DECISION DELEGATED TO DEVELOPMENT MANAGER

Application No: H15-1013-19 **Applicant:** Mr A Hubbard - Red Roof Developments

Proposal: Details of archaeology, materials, landscaping and agreement to tree work (Conditions 3, 6, 7 and 8 of H15-1103-18)

Location: 6 Town Drove Quadring Spalding

Elevations Proposed

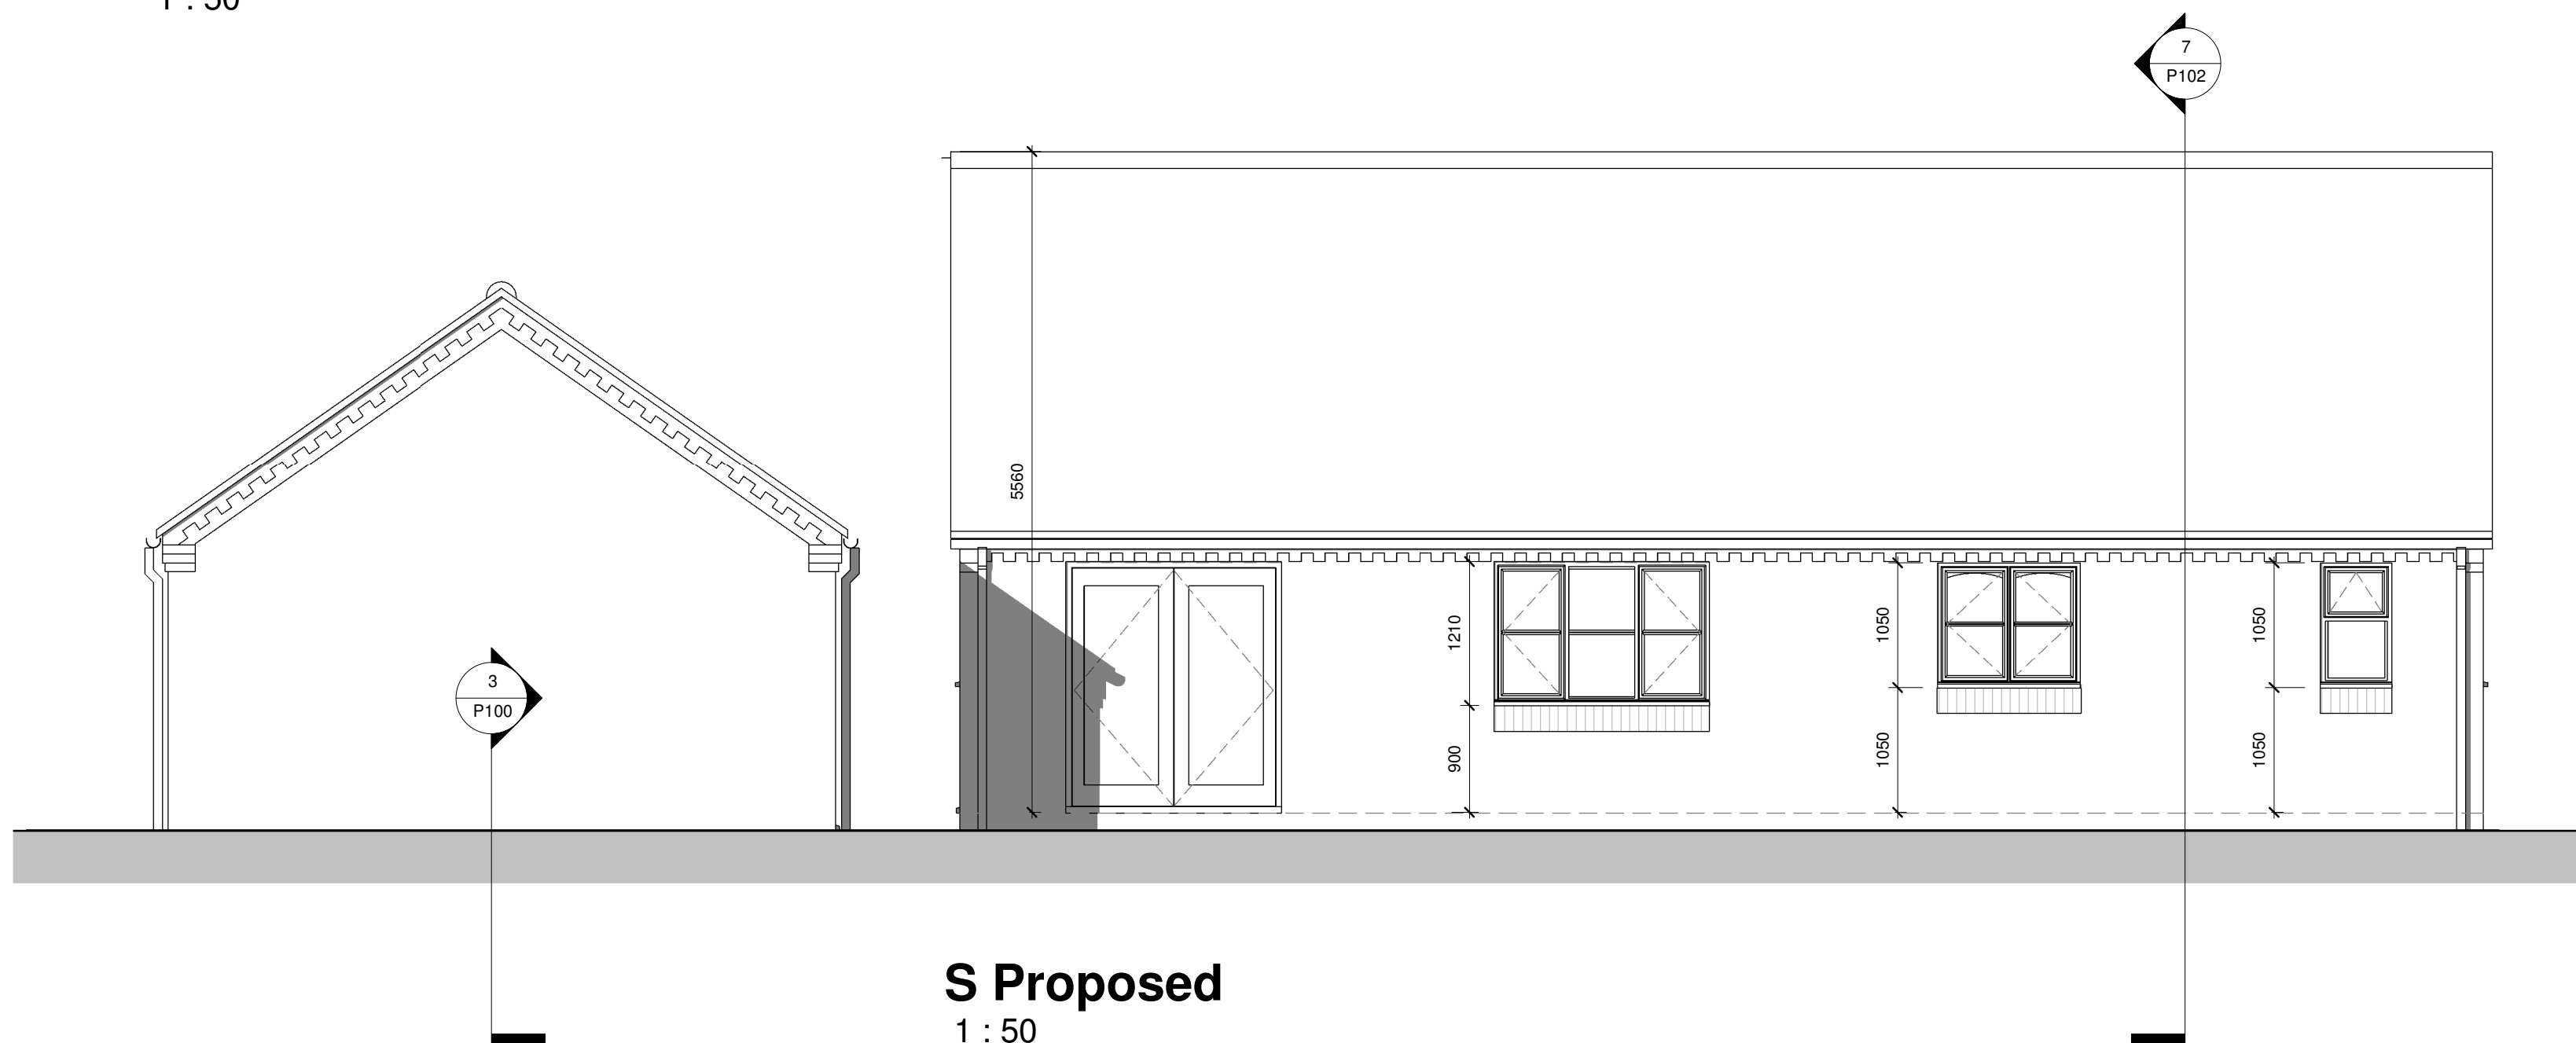
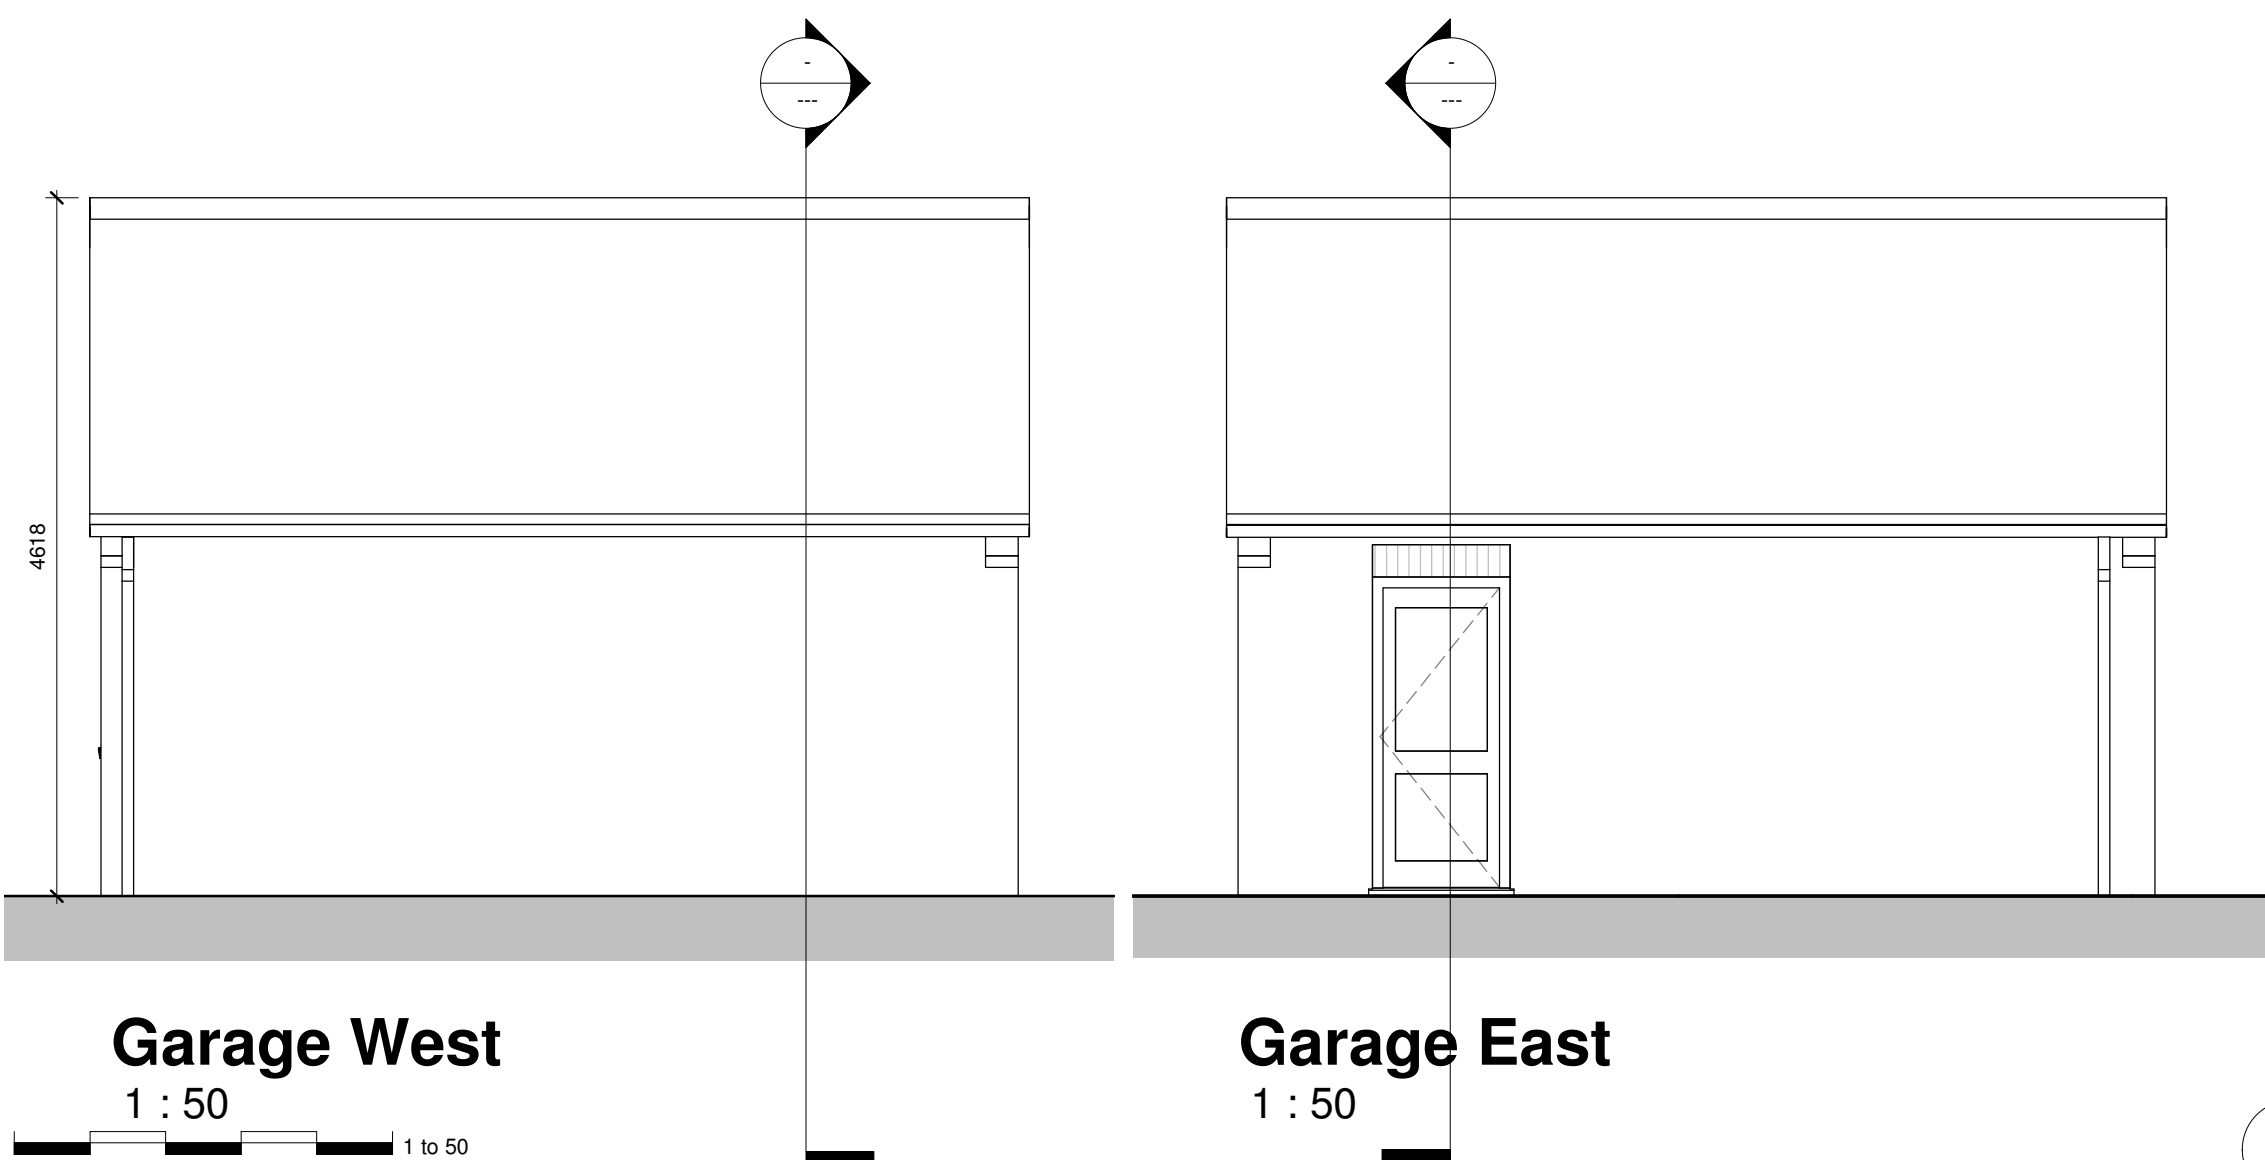
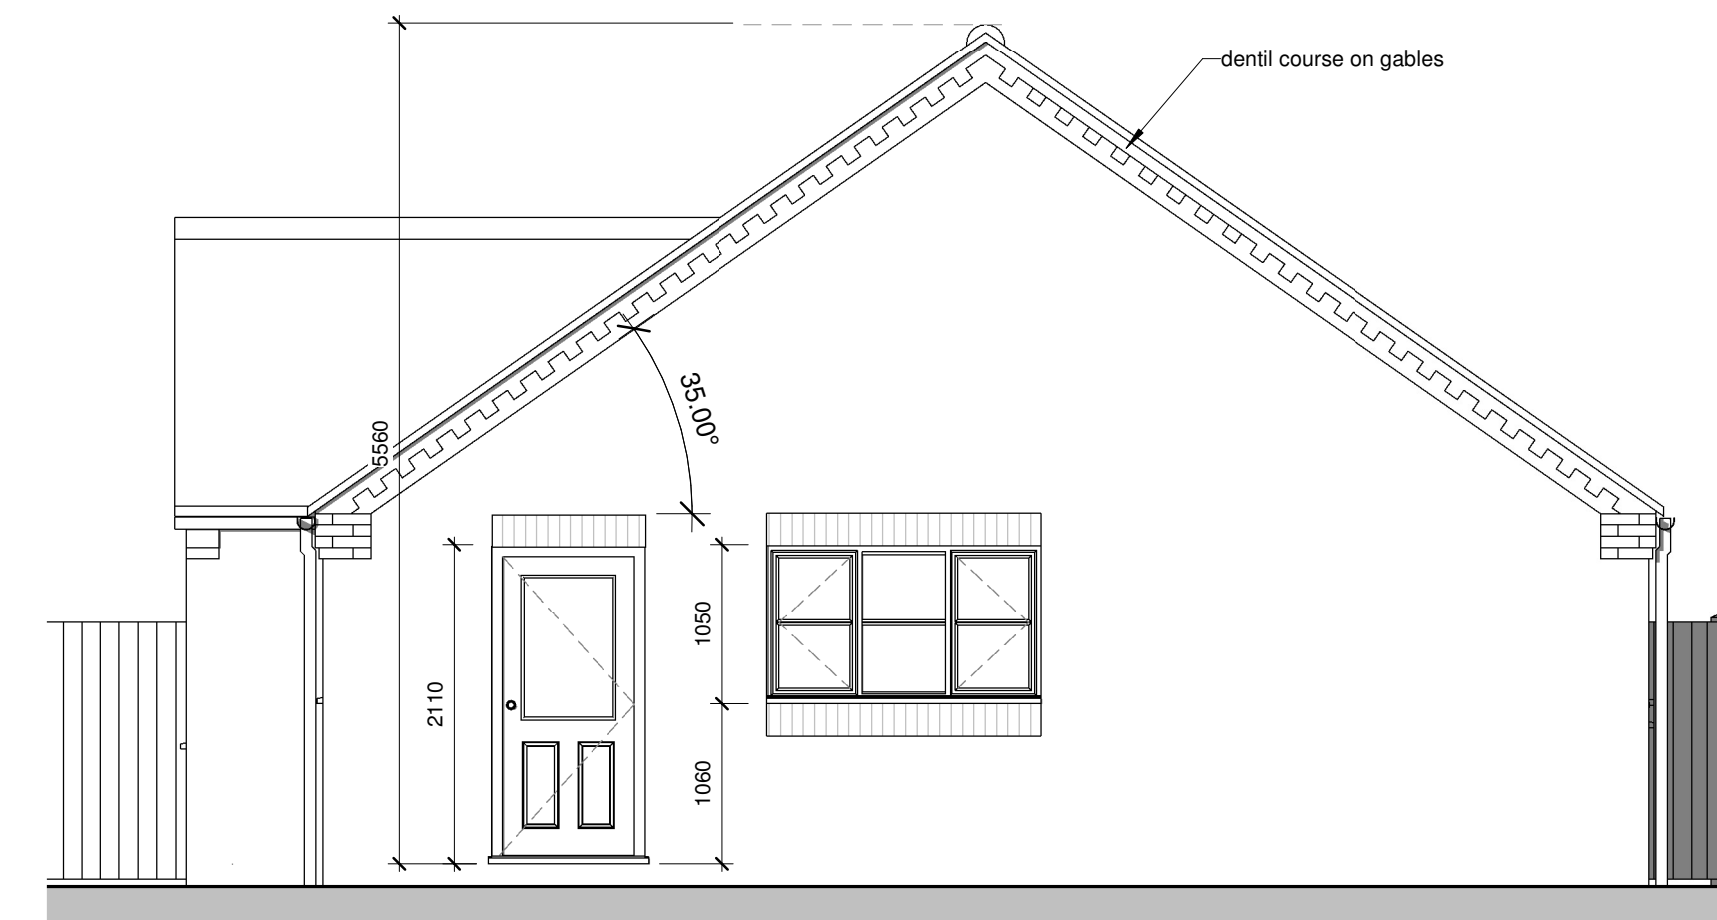
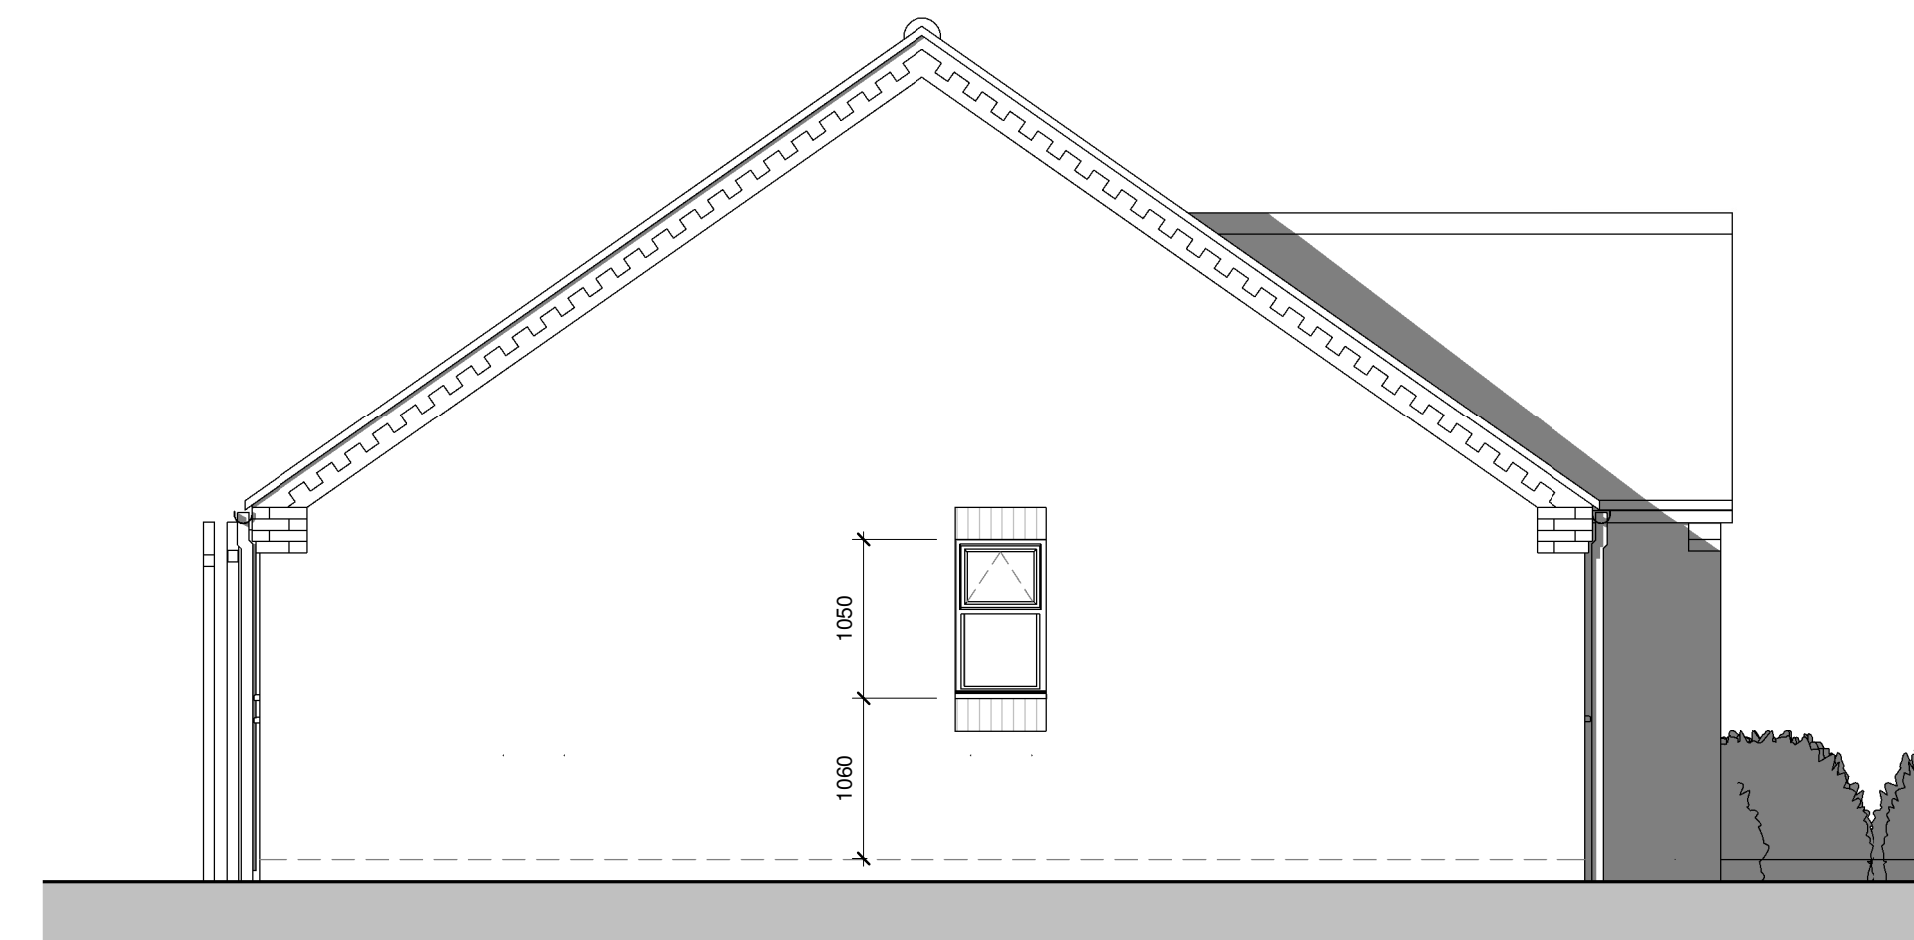
The proposed materials of construction are Forterra Hampton Rural Blend bricks and Sandtoft Double Pantile Rustic tiles. This is acceptable taking into account the variety of materials used in the construction of existing buildings in the vicinity and the specific materials of the Grade II Listed Building (Town Drove (south side) further west (red facing brick and terracotta pantiles).
